**WEST SUSSEX COUNTY COUNCIL
INFRASTRUCTURE CONSULTATION**

SUBJECT: BR/145/10-2no. 3 bedroom dwelling houses and removal of rear single storey extension to existing property.

Land adj to, 7, Nelson Road, Aldwick, PO21 2RY

**Advice
Objection**

Site Information

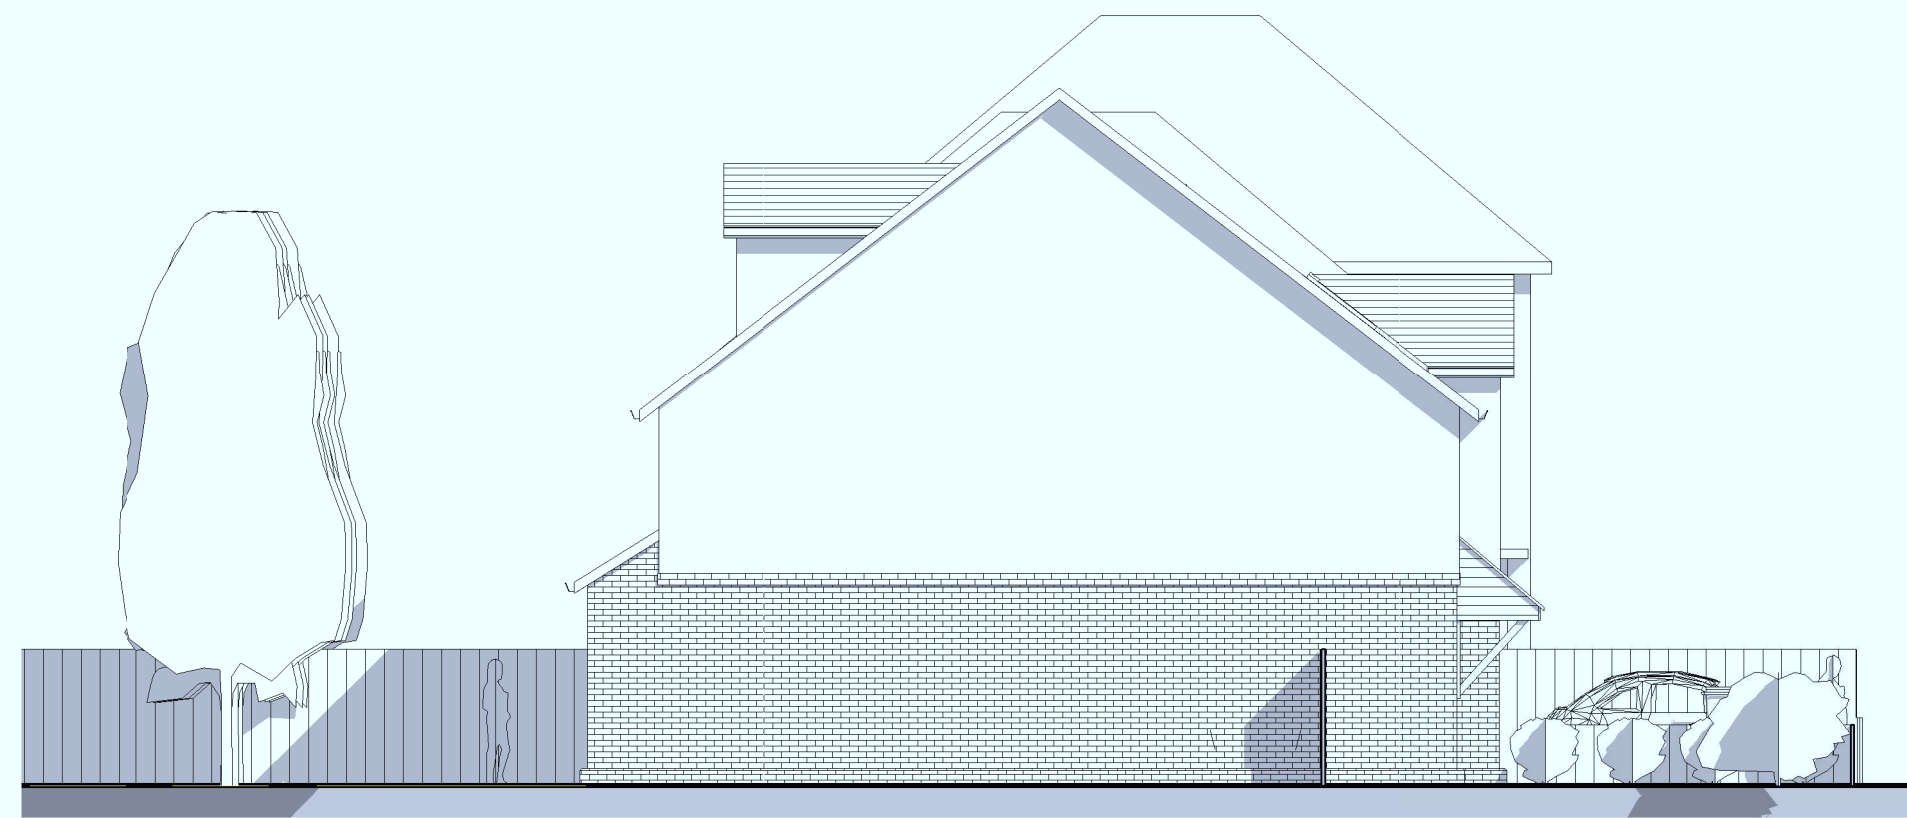
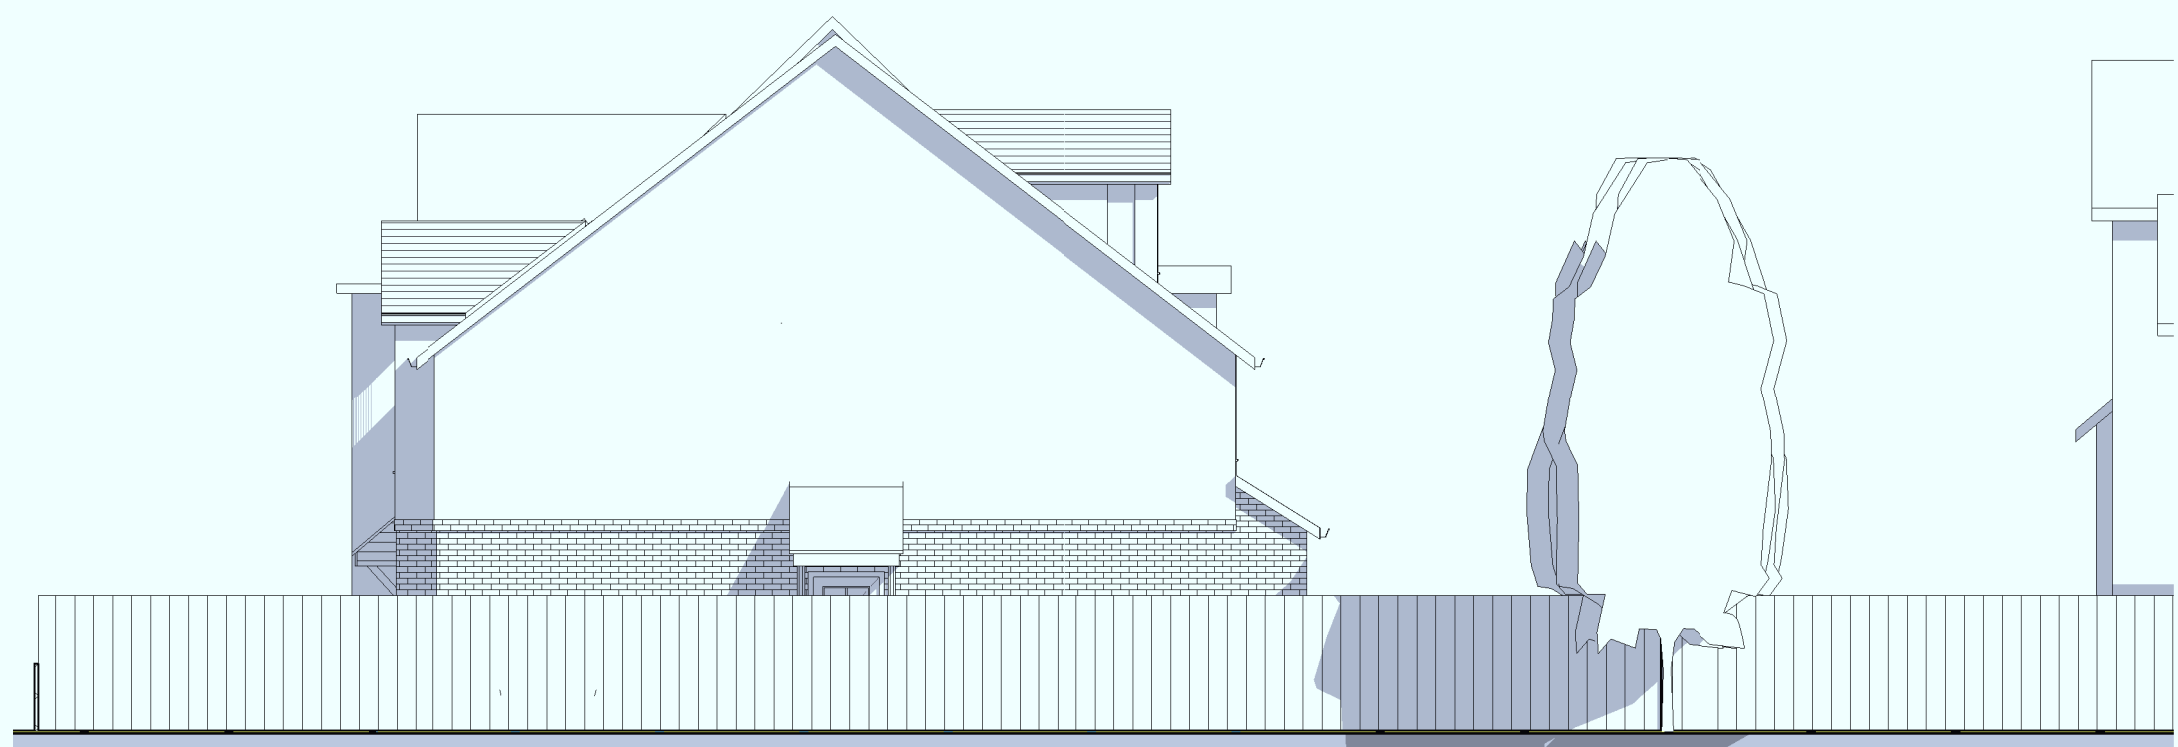
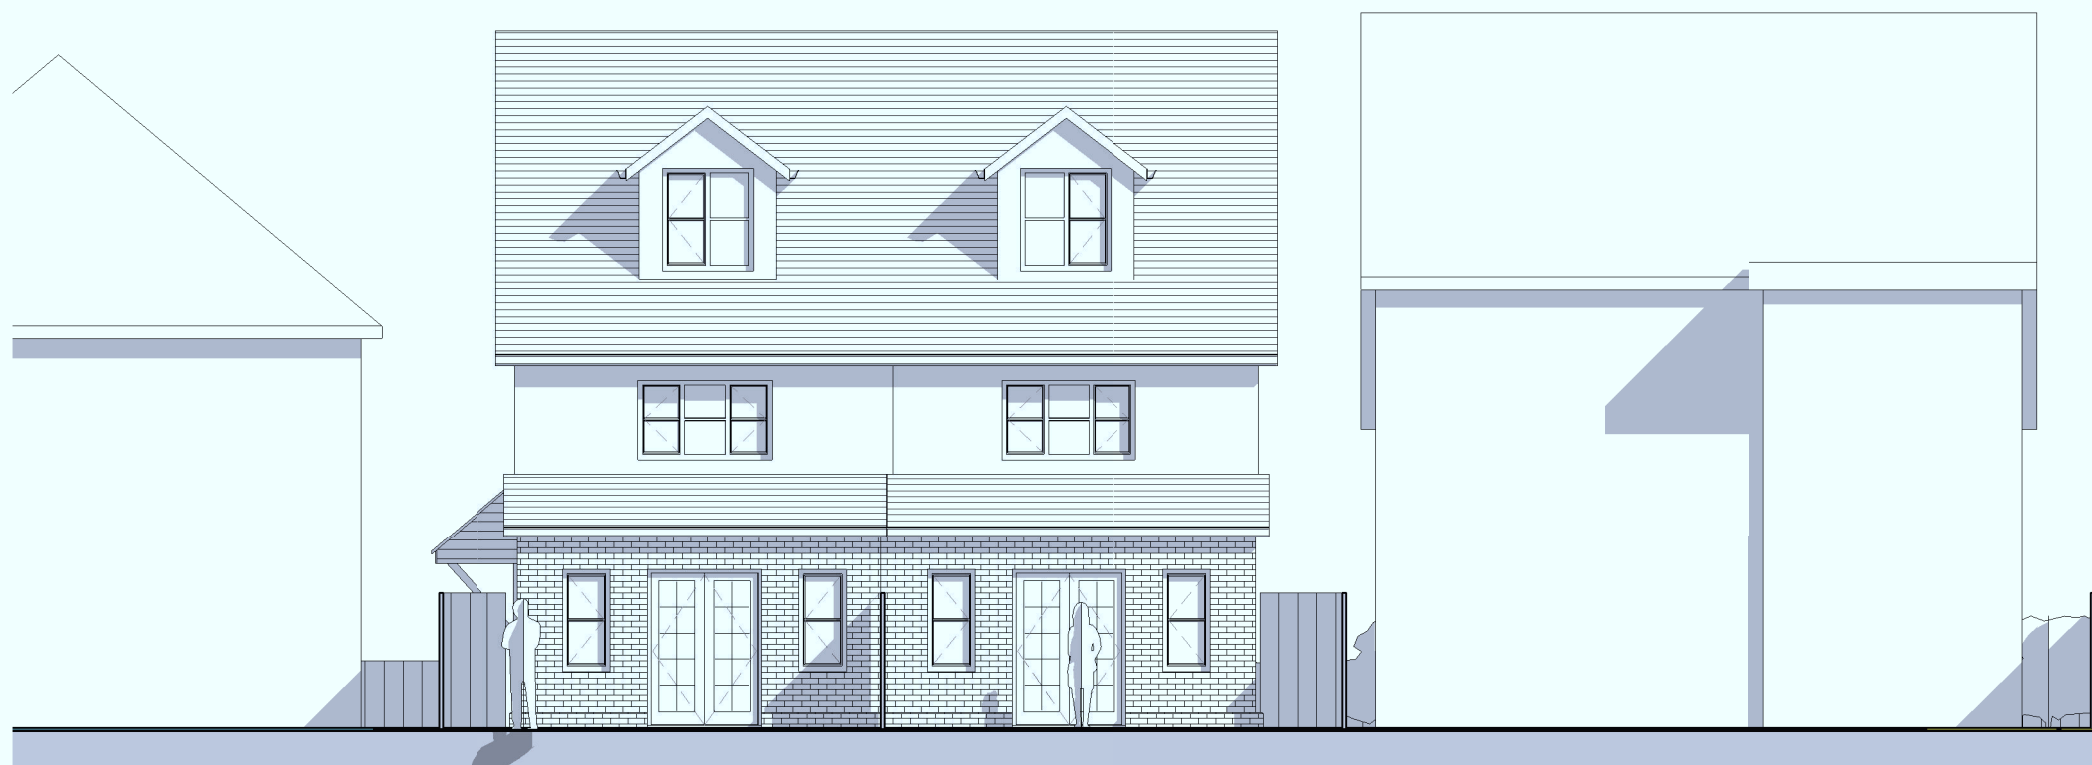
The proposed new dwellings will be served by new access points onto Nelson Road. As the accesses are only serving the two dwellings, a 4.0 metre wide access would be required. Any works on the highway must be agreed with the WSCC Local Engineer and carried out under licence. I would also require each driveway area and car parking spaces to be constructed in a bound material and that suitable drainage methods are installed to prevent private surface running onto the public highway.

The proposed car parking provision is within and does not exceed the WSCC Maximum standard. The site is located in an accessible location with Bognor Regis town centre and passenger transport facilities are within reasonable walking distance. With this taken into account cycle parking should be included; this must be secure, covered and be capable of storing at least one cycle per bedroom of the proposed dwelling. The actual details of the cycle parking facilities should be submitted to and approved by the Local Planning Authority (LPA). To accommodate cycle parking it would be recommended that any cycle store should have minimum dimensions of 2m x 1m.

As stated above off-street car parking is shown but there is no on-site turning space. From measuring the submitted plan, there is inadequate space to be able to provide this facility. This will inevitably result in vehicles reversing onto the public highway. However visibility splays for vehicles have been shown on the proposed plan number 002C; these would appear to be achievable and should be secured via condition. It would appear that other properties have similar arrangements with regard to their driveways with no apparent omission.

Nevertheless I would request that visibility splays for pedestrians are present at the new point of access onto Nelson Road. These should be 2 by 2 metres and should be kept free of all obstructions over 0.6 metres in height.

On the understanding that cycle parking is included, pedestrian and vehicular visibility splays are provided, no significant concerns would be raised to this application.

If the LPA are minded to approve this application, a condition securing the new access, cycle parking and provision of pedestrian and vehicular visibility splays prior to occupation of the dwellings should be included.
